From: Austin Rose, PE

Date: 21 July 2020

Re: **Northcrest Business Center: Traffic Memorandum
El Paso County, CO**

ARCHENGR:	KEM
DRAWN:	JDB
CHECKED:	km
DATE:	06.18.21
REVISION:	DATE
JOB NO.:	180649
SHEET NO.:	DP.02

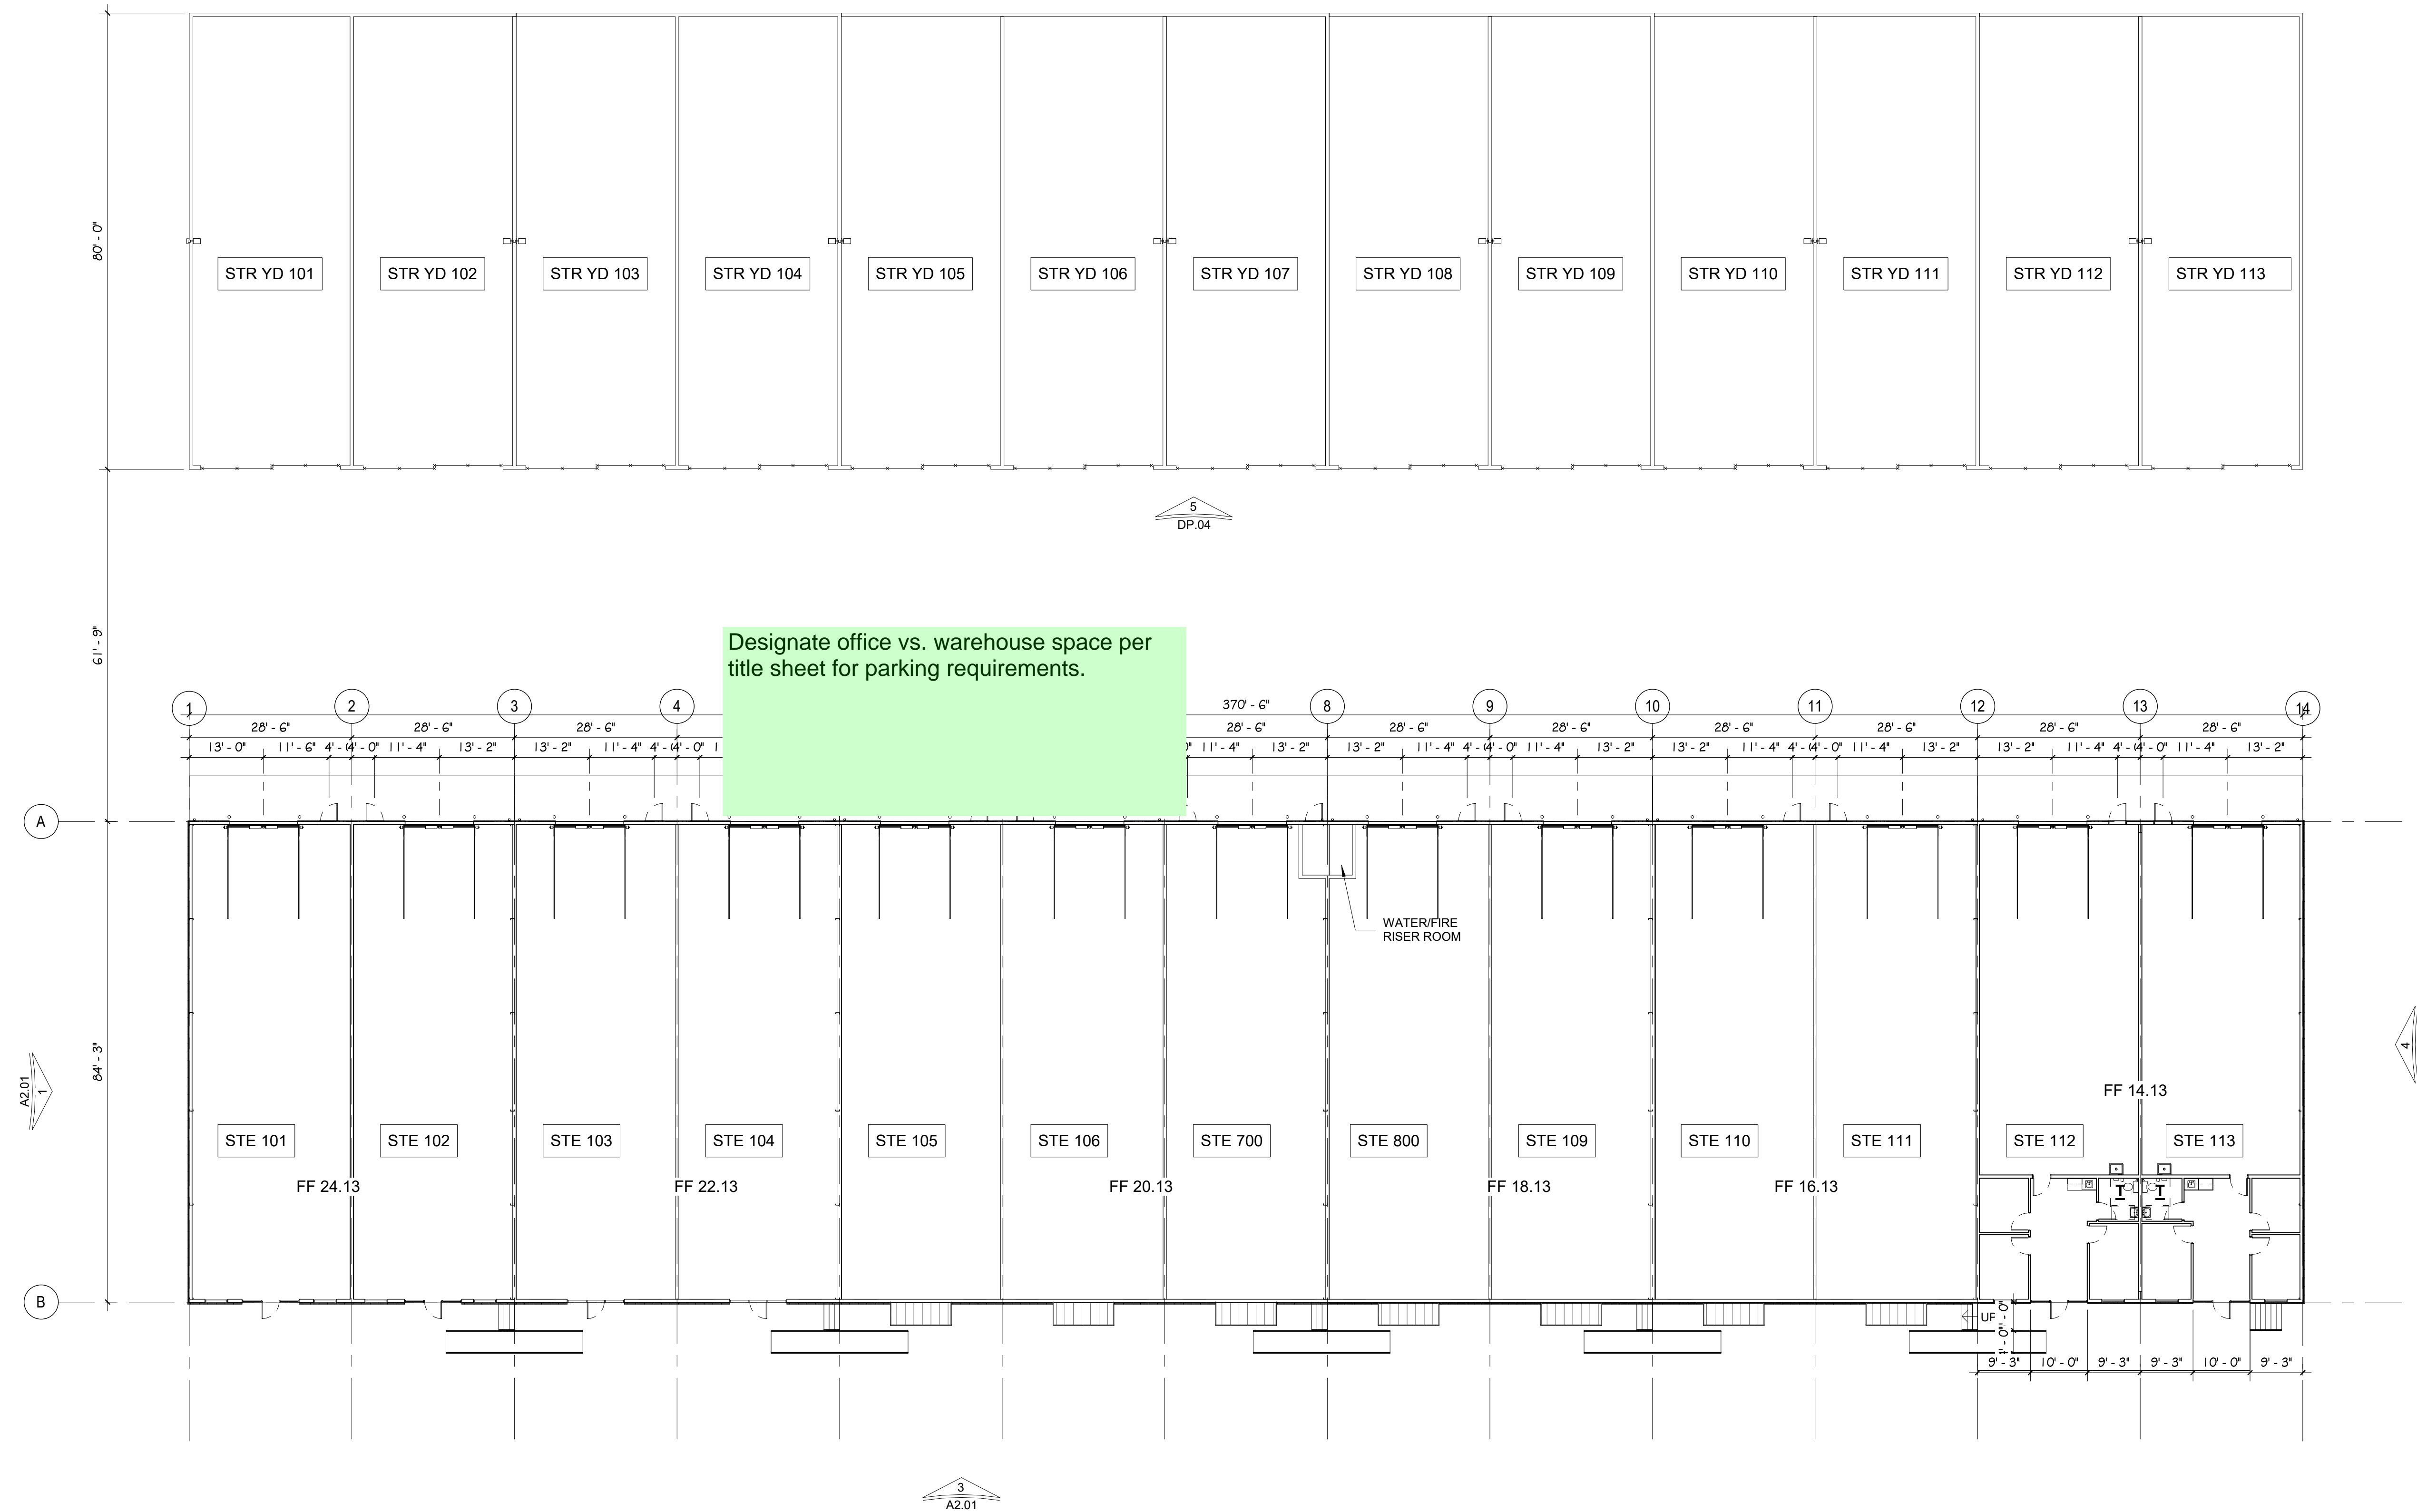
- Please discuss the location of driveway access points. Per the ECM 2-33, there should be a minimum of 150 feet between access points on roads with a 25 mph speed limit. On Canada Dr two access points are being proposed, and they do not meet criteria.
- State whether the MTCP or other studies call for construction of improvements in the immediate area.
- State road impact fees that will be due for this project.
- State what the ADT and peak hour traffic levels are at all accesses currently, full development, and twenty years out.

Traffic Memo's description states there are multiple accesses proposed. Please show and label access locations.
